from
**Southern
Water**

Your ref
A/86/20/DOC

Proposal: Approval of details reserved by condition imposed under ref A/51/14/OUT relating to Condition Nos 19 - foul water sewerage disposal, 20 - public water supply.

Site: A/86/20/DOC: - Manor Nursery, High Street, Angmering, BN16 4AW.

TITLE Site Layout
Southern Water Asset Constraints

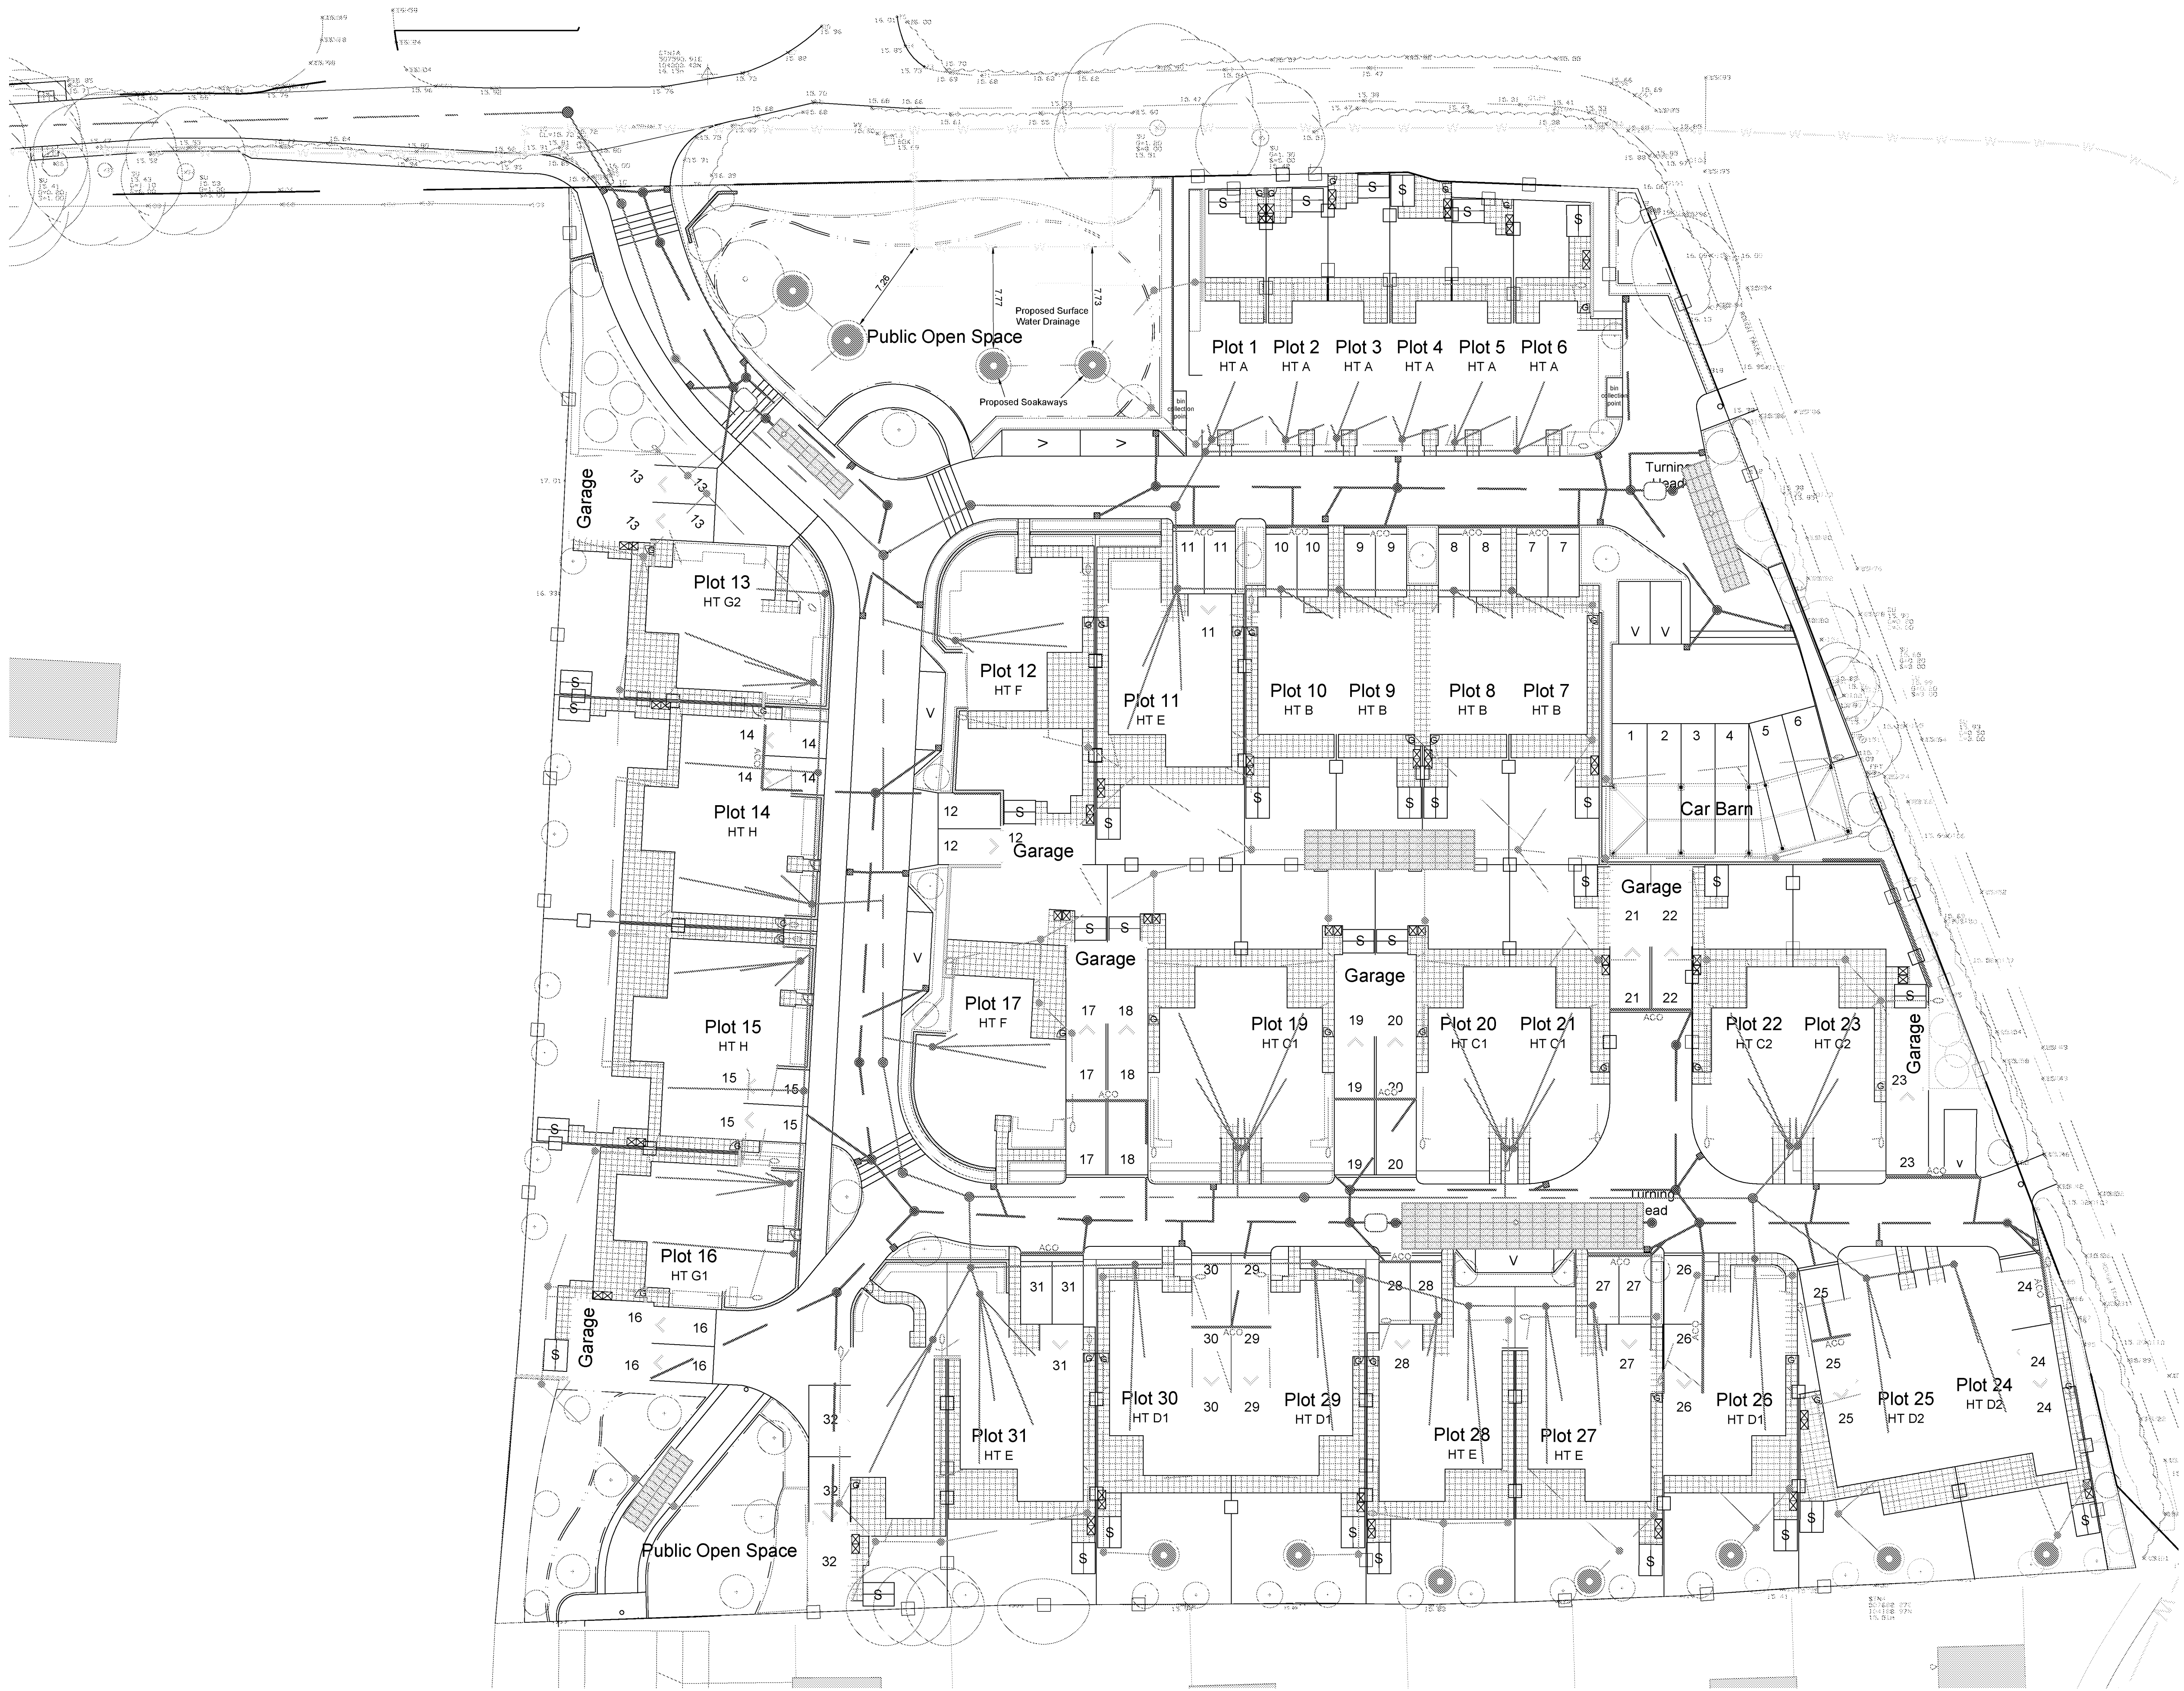
The submitted Site layout drawing (drawing no: 22995_110_A) shows easement on either side of the water main which is acceptable to Southern Water.

Southern Water would have no objections to discharge condition 20 relating to public water supply.
